September 27, 2007

Re: 31 Lennox St., CBL: 430-A-008, Exemption for Retaining Wall

Thank you for submitting a site plan exemption for the replacement of a retaining wall on your property at 31 Lennox Street. The location of the retaining wall is within the Shoreland Zone.

Building material and construction description.
For city of Portland planning department.

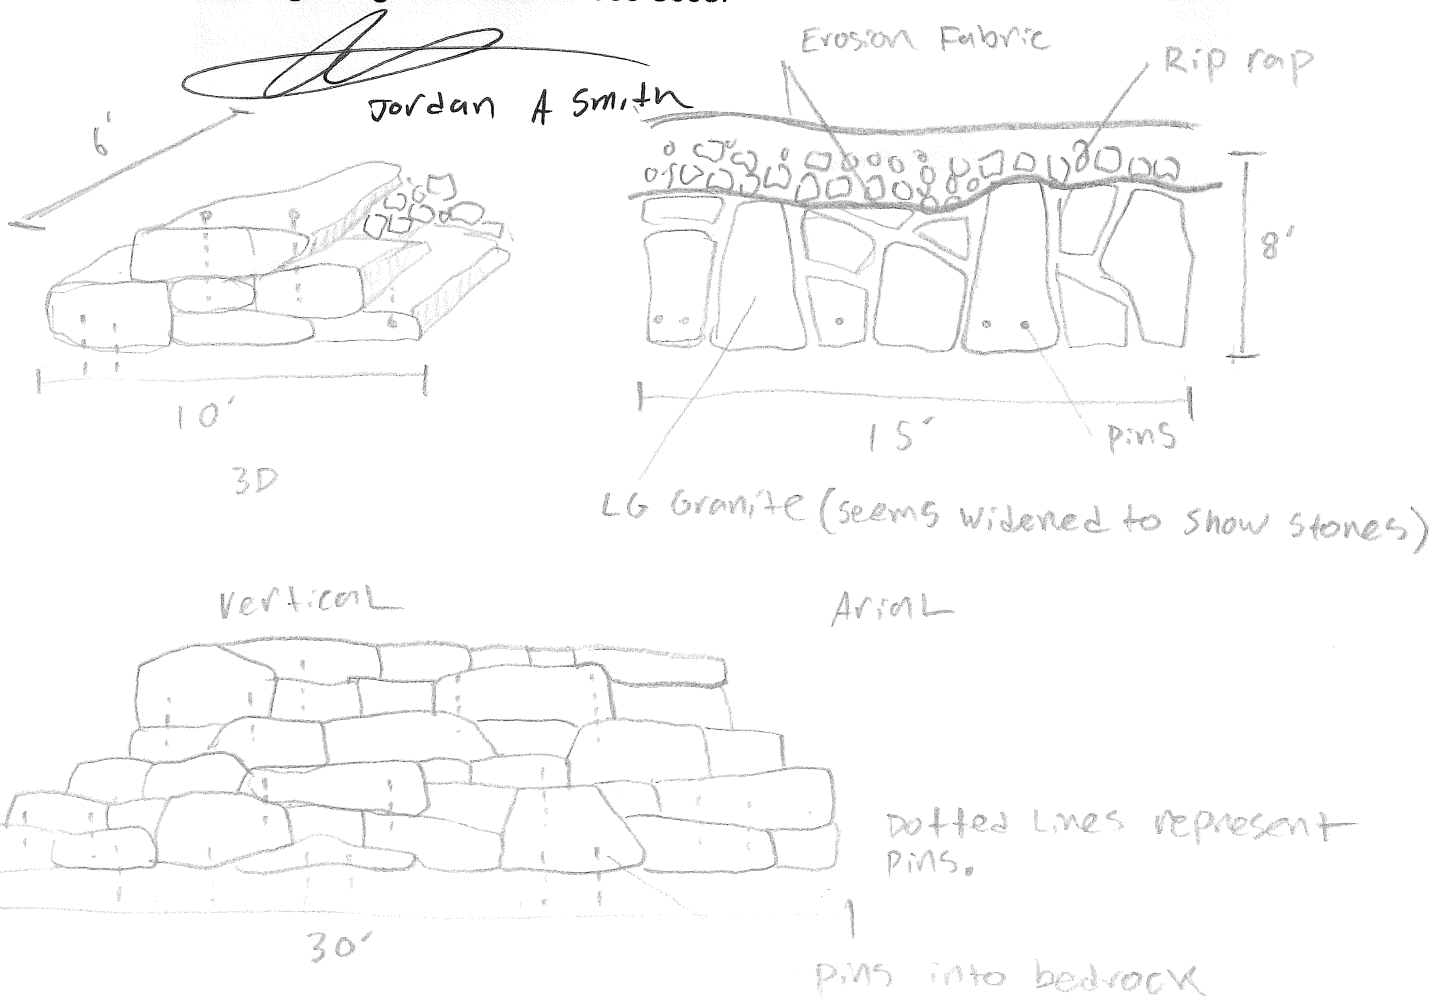
For your information, I did present the plan at our weekly development review meeting for initial comments from staff members. Dan Goyette P.E, the City's consulting engineer, questioned the size of the proposed stones for the retaining wall. He suggested that you confirm with a professional engineer that the proposed stone size is adequate for the stability of the retaining wall.
